***MODIFICATION REQUEST:
Thomas Street Car Park, Chatswood
MP 09_0066 MOD 10***

***Addition of two building identification signs
to Building 2***

Secretary's
Environmental Assessment Report
Section 75W of the
Environmental Planning and Assessment Act 1979
August 2014

SOUTH-ELEVATION

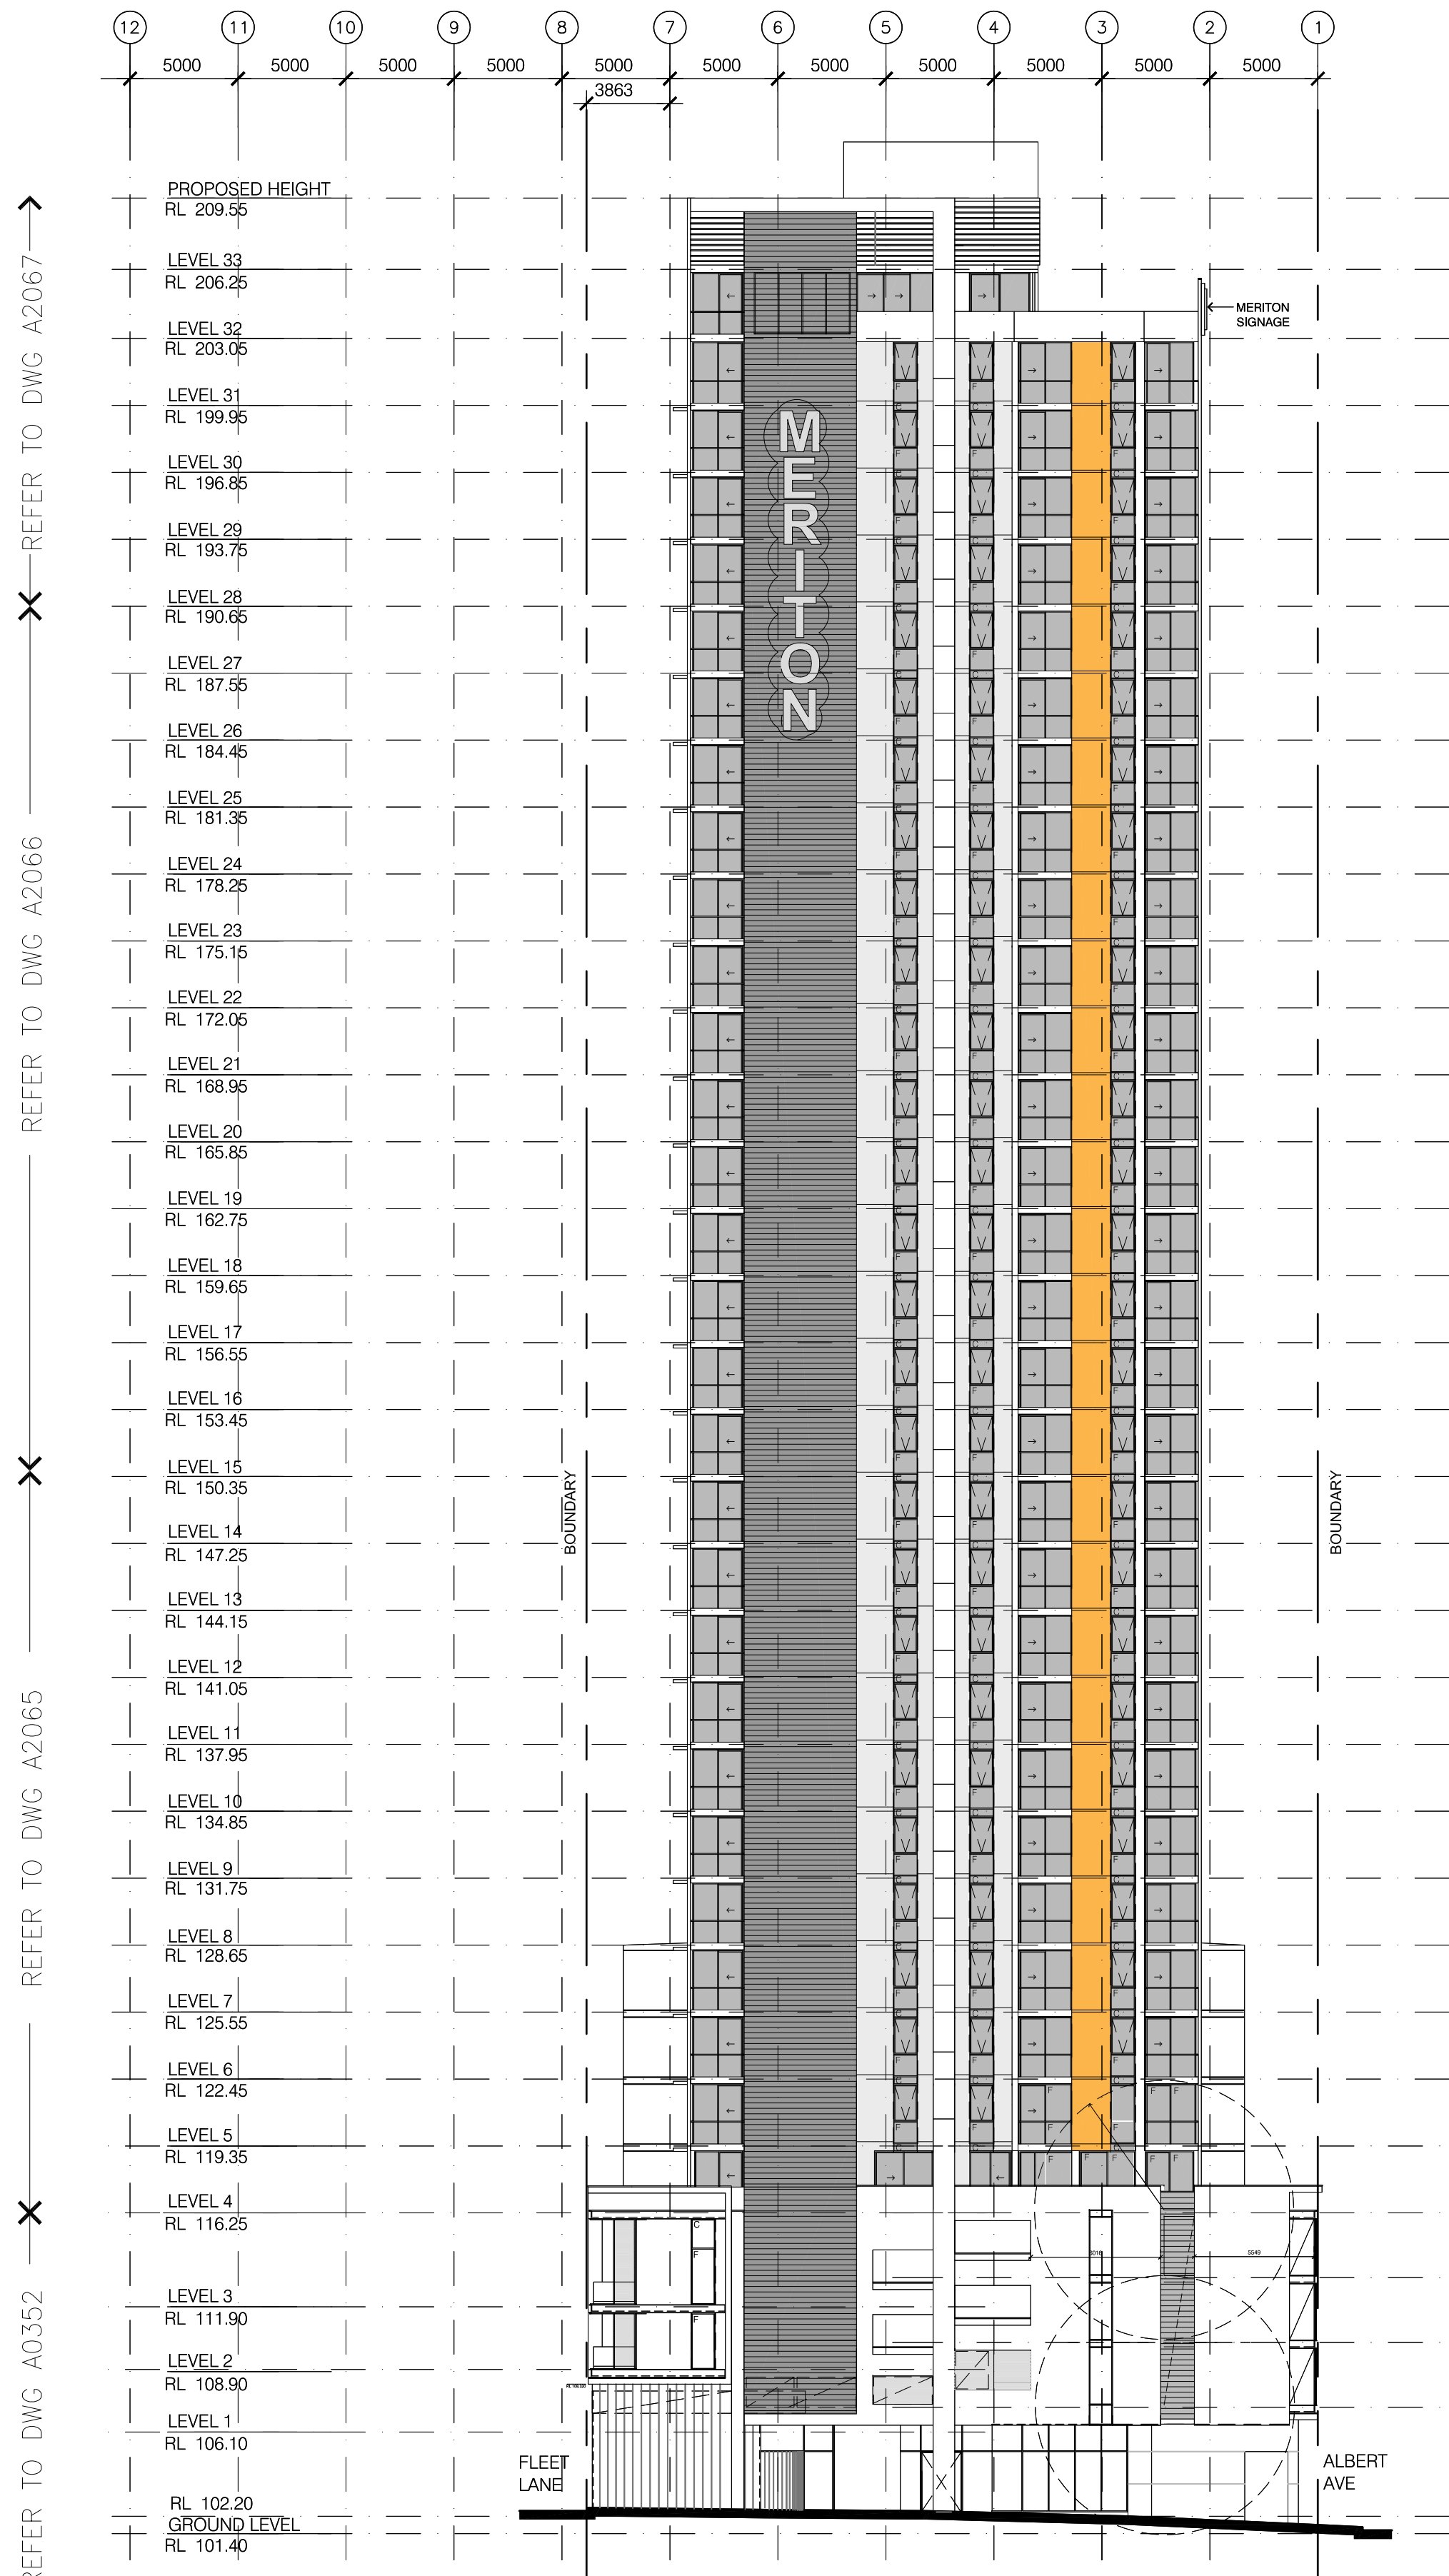
Council did not object to Sign 2, however did not support the location of Sign 1 on the southern elevation at Level 32 as originally proposed. Council recommended that the proposed Sign 1 be relocated to Level 33 affixed to the façade of the plant room.

The proponent responded to Council's submission with amended architectural plans illustrating the proposed location of Sign 1 on the southern elevation at Level 33, affixed to the façade of the plant room (as per Council's recommendation).

Council subsequently confirmed that it does not object to the revised location of Sign 1 at Level 33.
